East Preston Parish Council

30th September 2026

Re: EP/79/26/PL – Salt Beach Kiosk, Sea Road, East Preston, BN16 1PD

Proposed

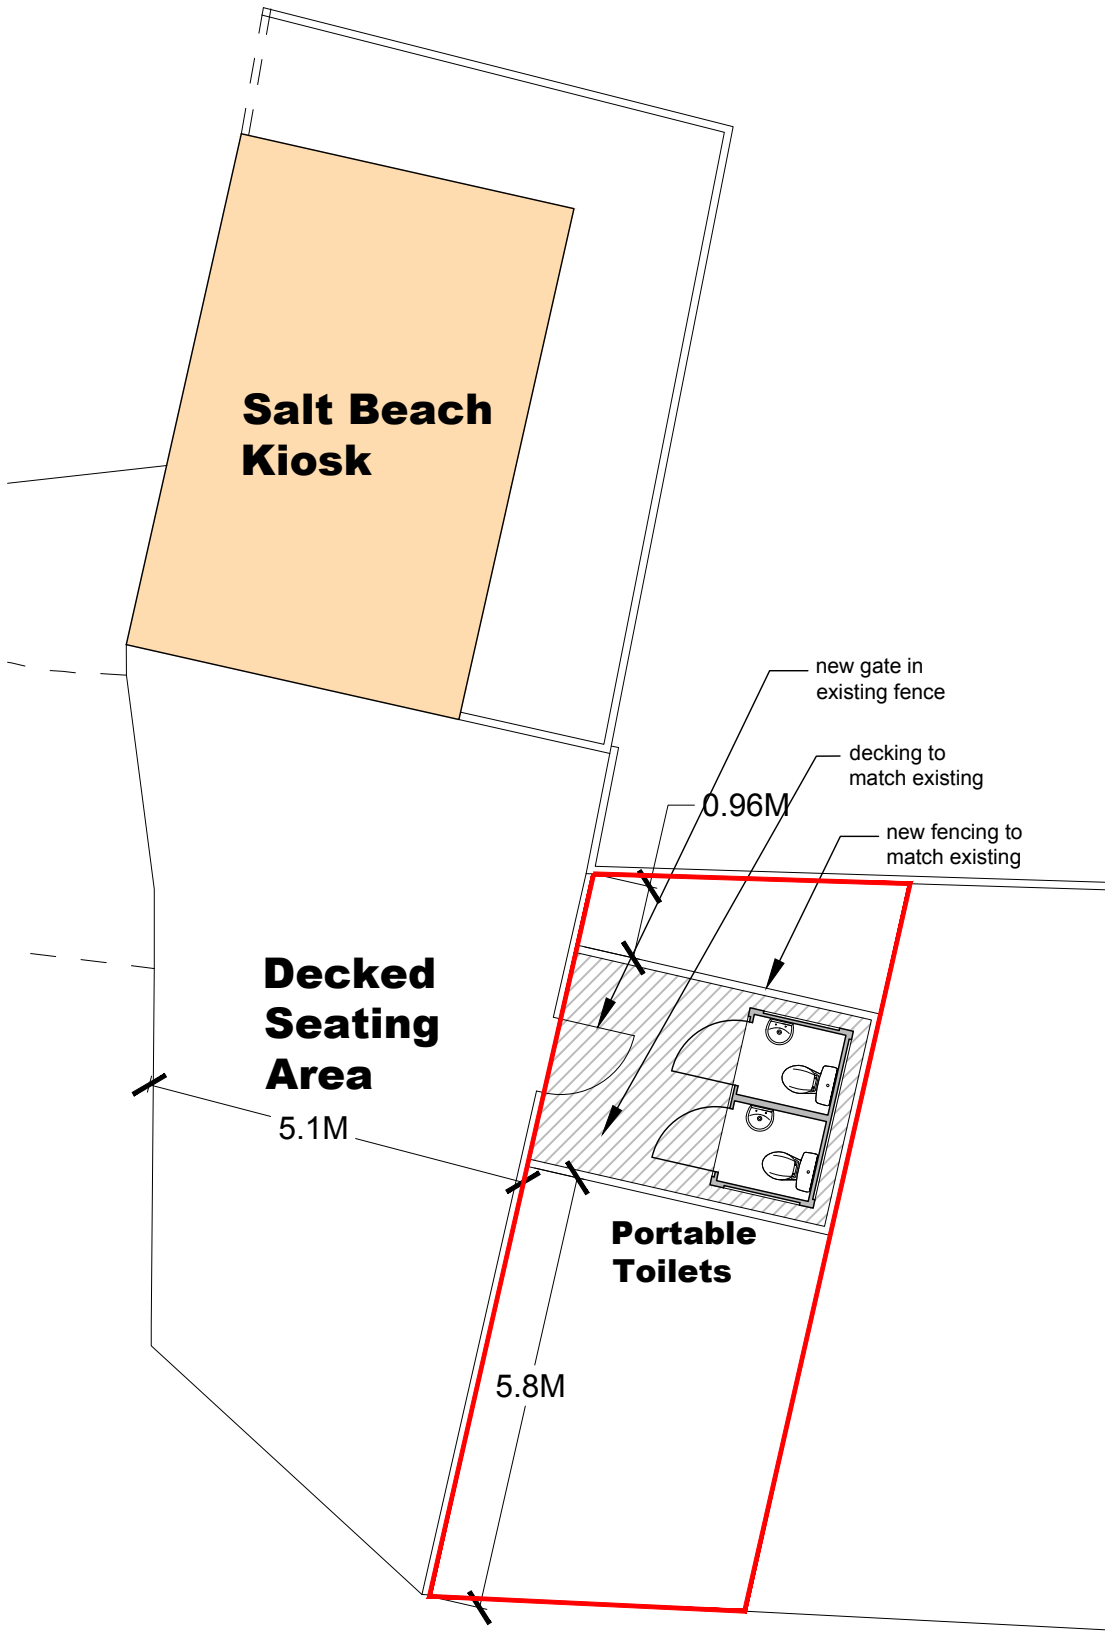
Please could some indication be given as to an cleaning and emptying schedule for the toilets and from where they will be accessed for emptying.

Could further consideration be given to one of the toilets being an accessible toilet?

Will the portable sauna immediately to the east of the proposed toilets be moved further east?
